# LSC Responses to EPC TIS Redline Comments

## Falcon U-Haul Traffic Impact Study (LSC #S224140) August 26, 2022

Please Add PCD File <sup>1</sup>  
#SF-22-40 &  
PPR-22-56

Figure 2  
**Site Plan**

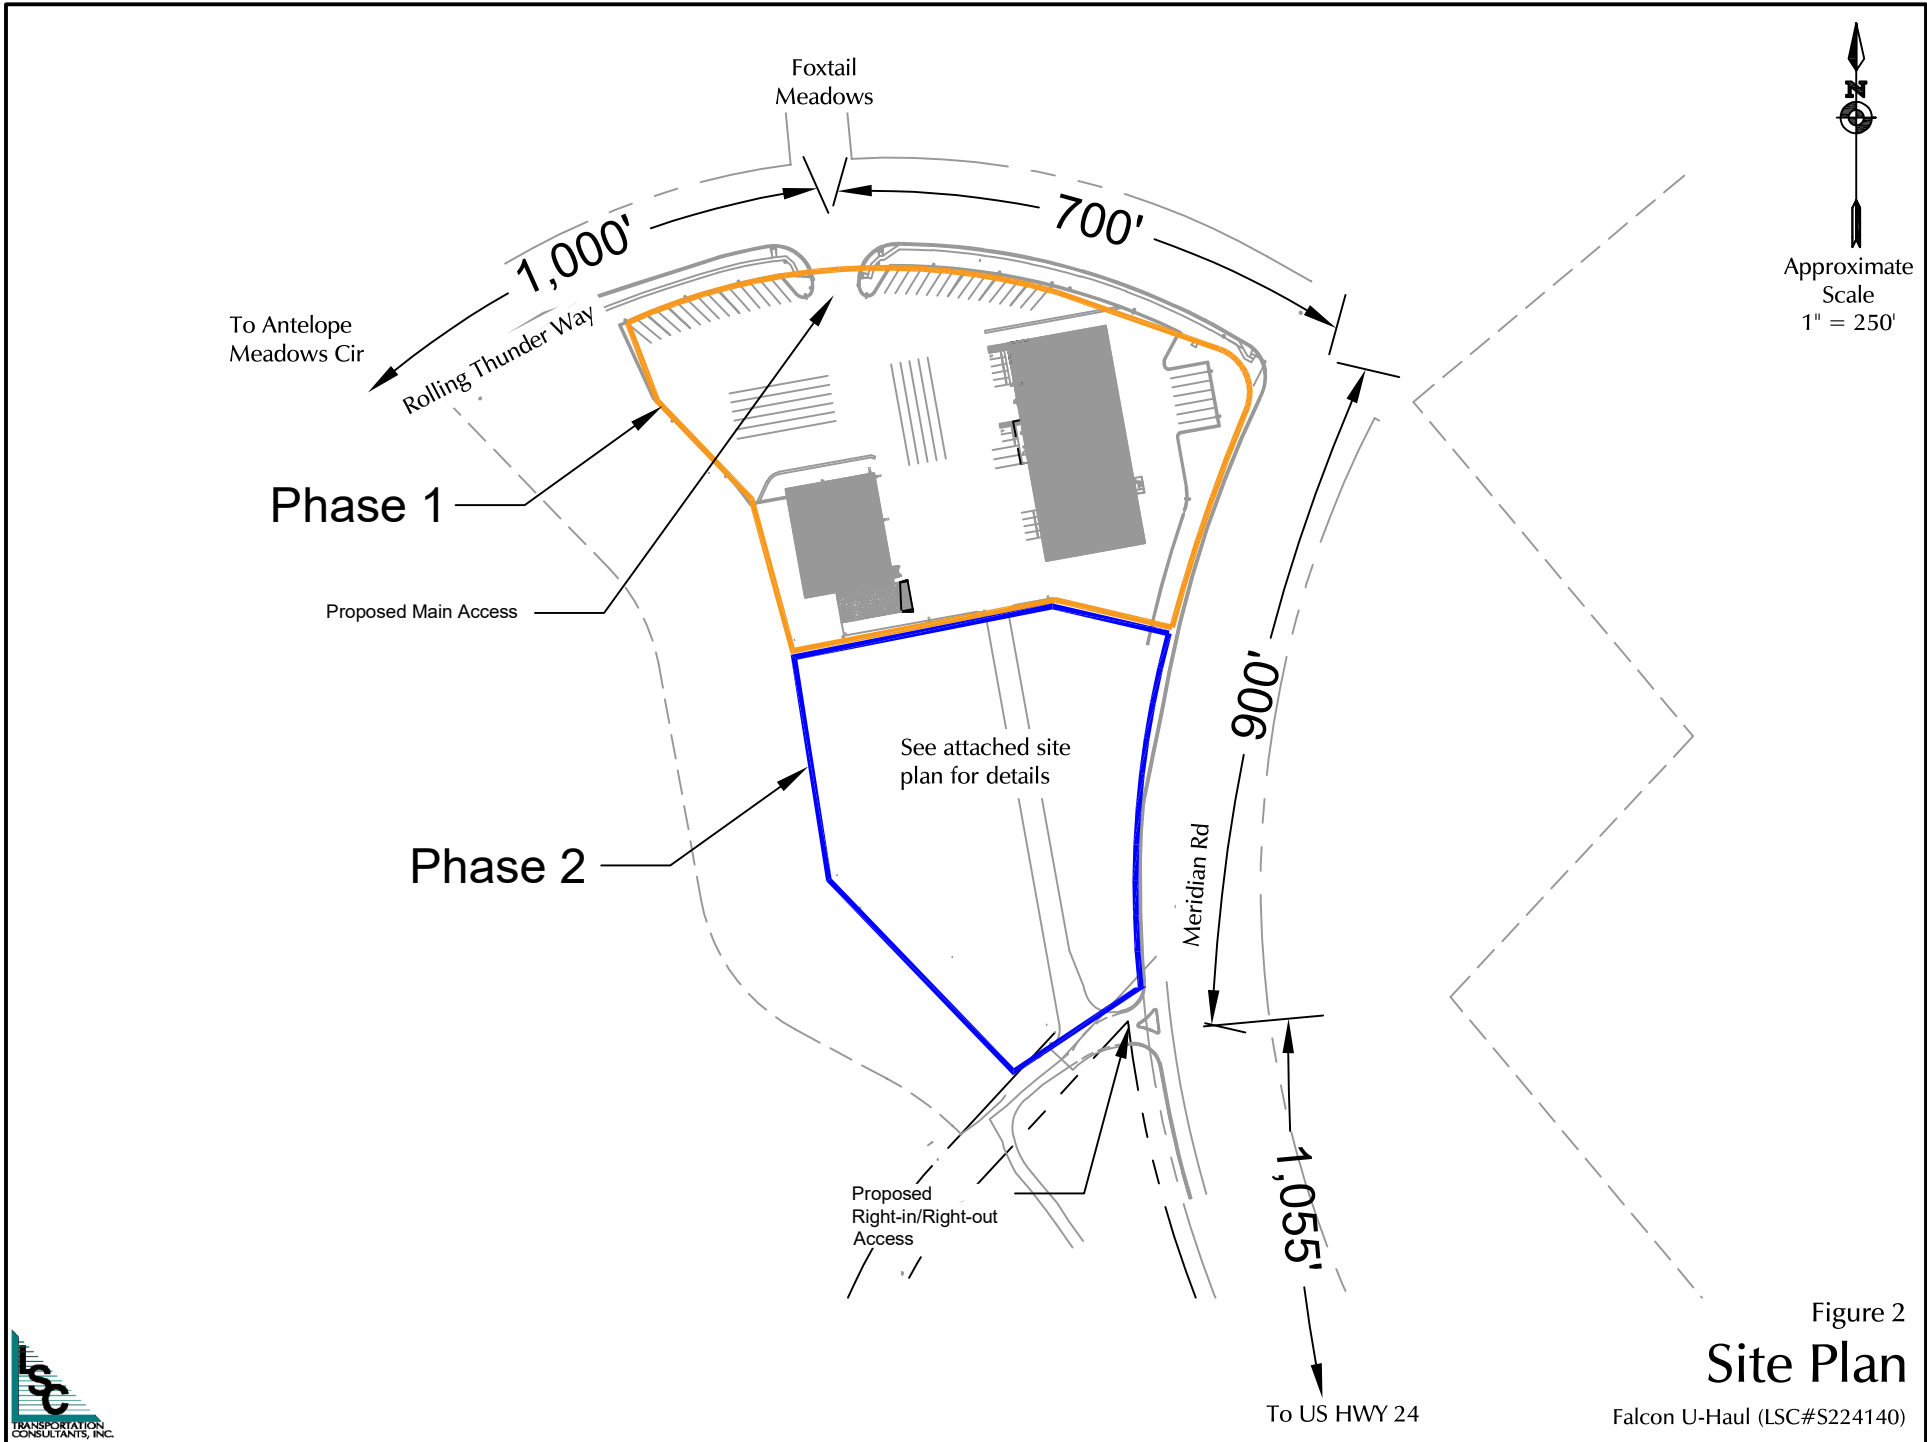
[Add Tamlin Road](#)

Author: jchodsdon Subject: Sticky Note Date: 5/31/2023 11:38:40 AM  
LSC Response: Added as requested.

Figure 9  
 2042 Background + Site  
 Traffic, Lane Geometry,  
 Traffic Control, and LOS

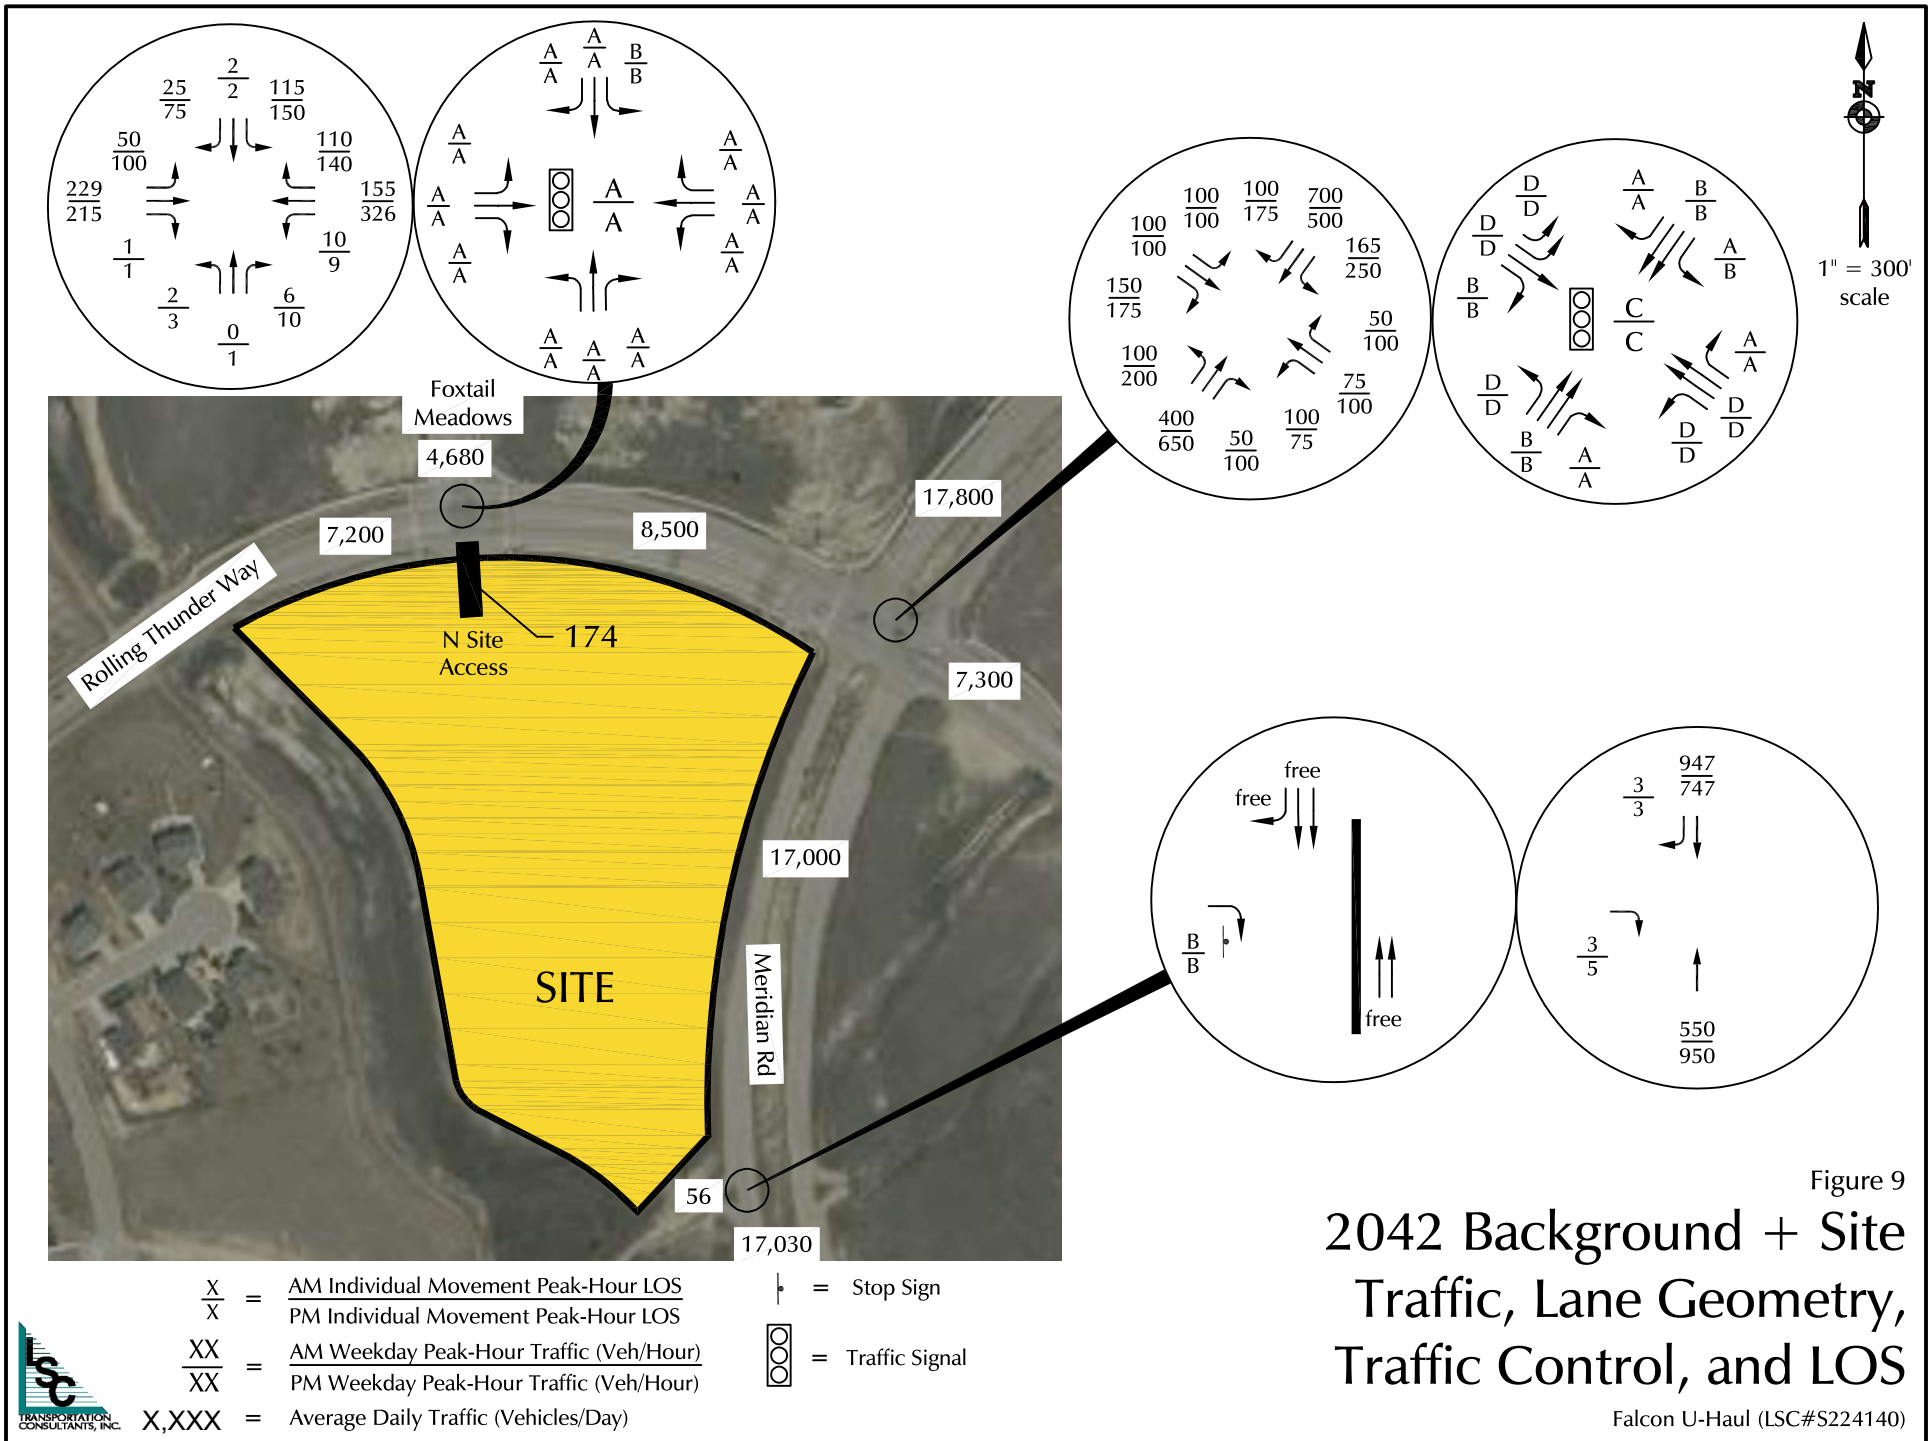
Elaborate on the background traffic estimates by including exhibits/table showing the specific future developments accounted for and distribution assumptions. Through 2014 this lane was striped for dual left turn. Staff's main concern is regarding the recommendation for restriping the southbound approach to a through lane. Specifically, the TIS shall address if the "striped out" lane was intended for additional future left turn lane when the area is completely built out.

Discuss 2040 background + analysis and whether or not a southbound second left turn lane be warranted or is a single turn lane be sufficient since the intersection appears to have been originally constructed with two SBLT

LSC Response: This comment has been addressed in the updated report.

LSC Response: This comment has been addressed in the updated TIS.
